Appeal Decision

Appeal Ref: APP/R5510/D/24/3352816

68 Hatch Lane Harmondsworth West Drayton UB7 0BA

- The appeal is made under section 78 of the Town and Country Planning Act 1990 (as amended) against a refusal to grant planning permission.
- The appeal is made by Mr Rajbir Singh against the decision of the London Borough of Hillingdon.
- The application Ref is 11905/APP/2024/1332.
- The development proposed is a Two storey side extension.

PROPOSED
GROUND FLOOR PLAN

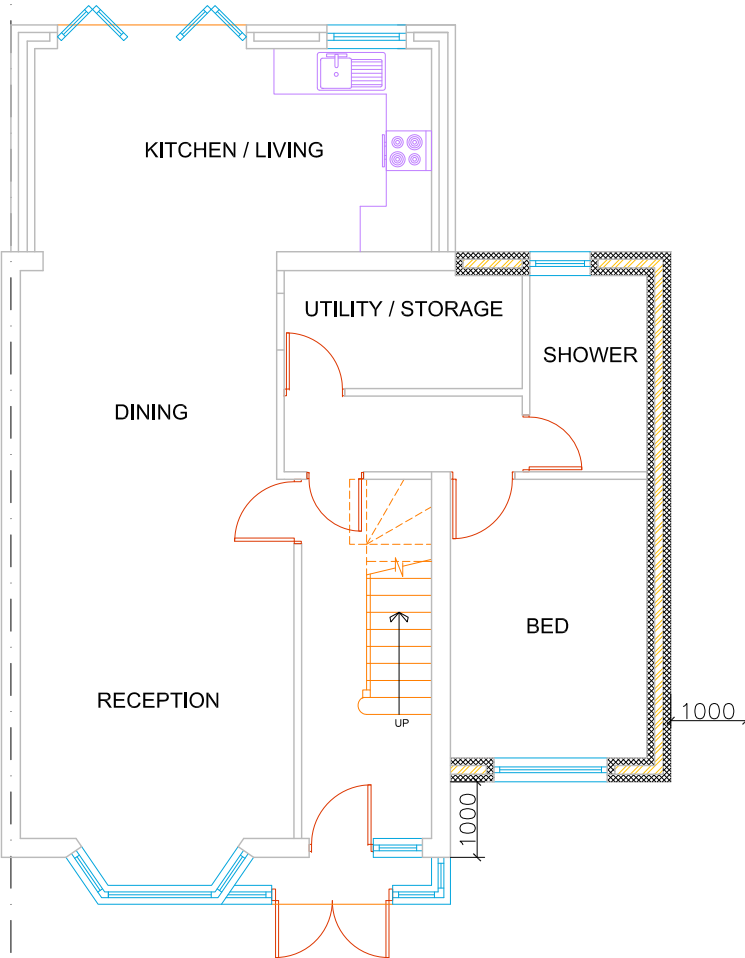
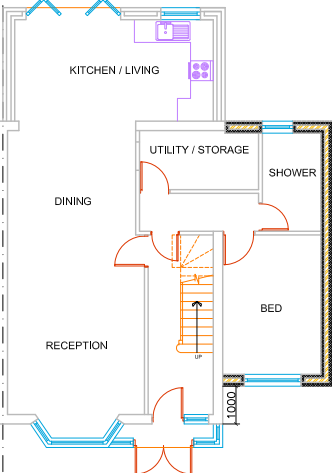
6. Little information is provided as to the proposed treatment of the curtilage which would be affected by the proposed extension. The extension would occupy the existing space at the side of No.68 leaving a 1.0m walkway within the side boundary, reducing the perceived¹ width between No.66 and No.68. Although this would reduce a desirable sense of openness at the entrance point to a part of the HVCA which retains, in the way outlined in the character appraisal, a degree of original character², I must determine the proposals with regard to the general duty set out in section 72(1) of the Planning (Listed Buildings and Conservation Areas) Act 1990 (LBCA) to preserve or enhance its character as a whole. I have already identified the absence of green softening and poor quality fencing/walling at No.68 as a harmful factor of significance, given the prominent position of the appeal site. Although these matters are finely balanced, it is my conclusion that a carefully detailed and well-considered scheme to improve boundary features and forecourt area that reflects more traditional features, together with some visual softening (planting), would make a positive contribution to the

street scene which could outweigh harm from the insertion of the side extension. Consequently, and notwithstanding the concerns of the Council as to the insertion of an upper floor level extension and the previous refusal of permission at No.66, I consider that overall, with suitable enhancements to the elements identified controlled by condition, the resulting development would, overall, preserve the character and appearance of the HVCA by improving the visual cohesion of elements which are prominent in the street scene.

- 4) Prior to the commencement of the development hereby approved a scheme for the treatment of boundaries and forecourt area including planting of trees shrubs or hedges, shall be submitted to, and approved in writing by, the local planning authority. The scheme shall include details of:

- Boundary treatments to the front, north side and rear of No.68 Hatch Lane,
 - Surfacing materials to the forecourt parking area,
 - Location and species of plantingand be completed in accordance with the approved details prior to the first occupation of the development, and thereafter retained for the lifetime of the development.
